5 Ferring Grange Gardens, Ferring BN12 5HS

From: Shear Architectural Design LTD [REDACTED]
Sent: 02 February 2022 12:27
To: Planning.Responses <Planning.Responses@arun.gov.uk>
Subject: Re: Request for further information FG/15/22/HH

Erection of part single, part two storey rear extension with Juliette balcony and installation of front window.

Block Plan
Scale: 1:500

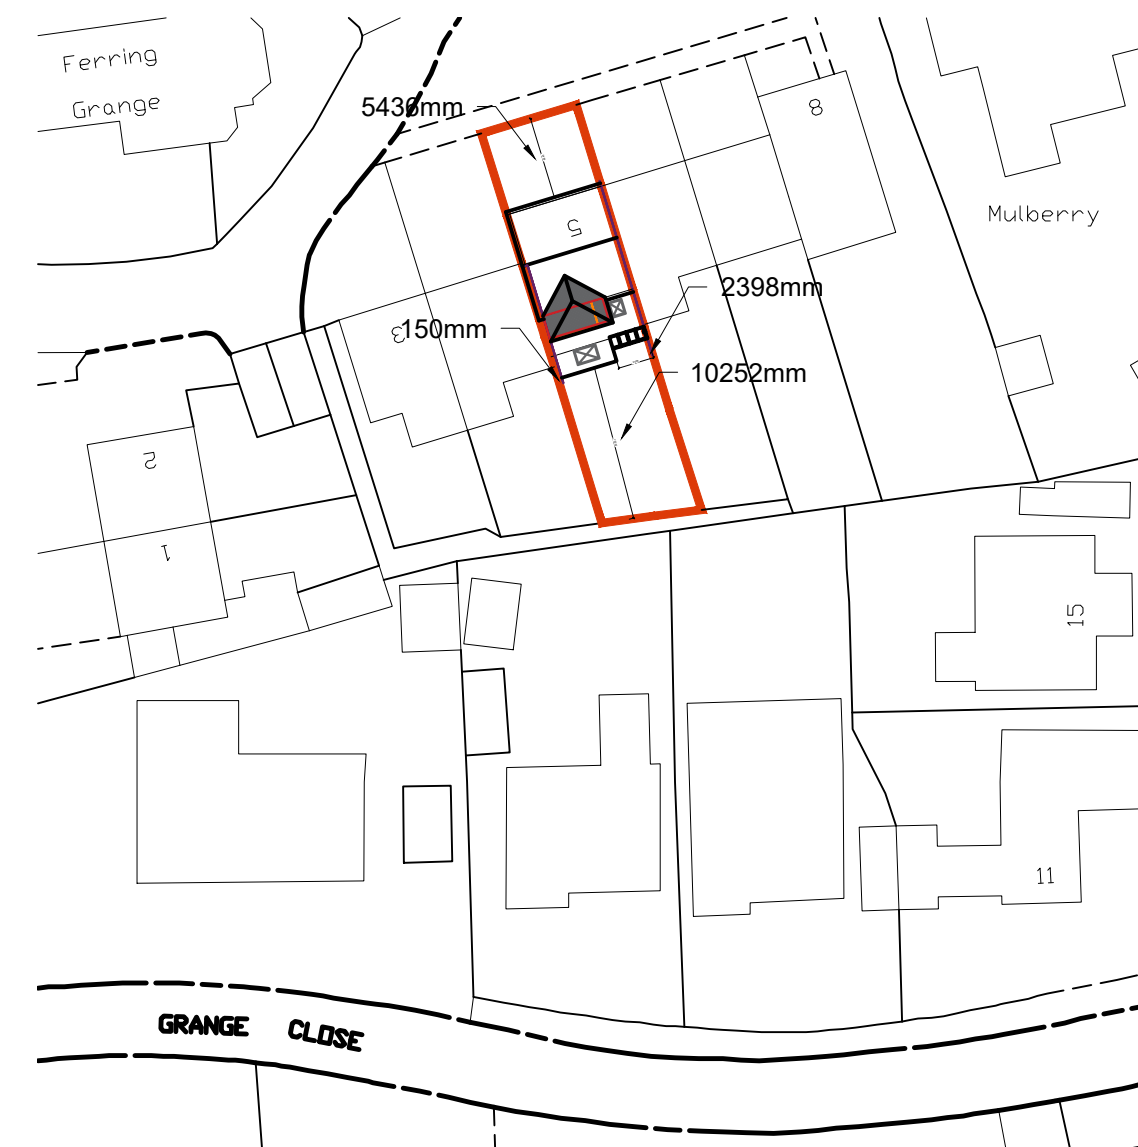
Block Plan

You are required to have dimensions from the proposed extension(s) to all site boundaries. Please amend.

ADDED
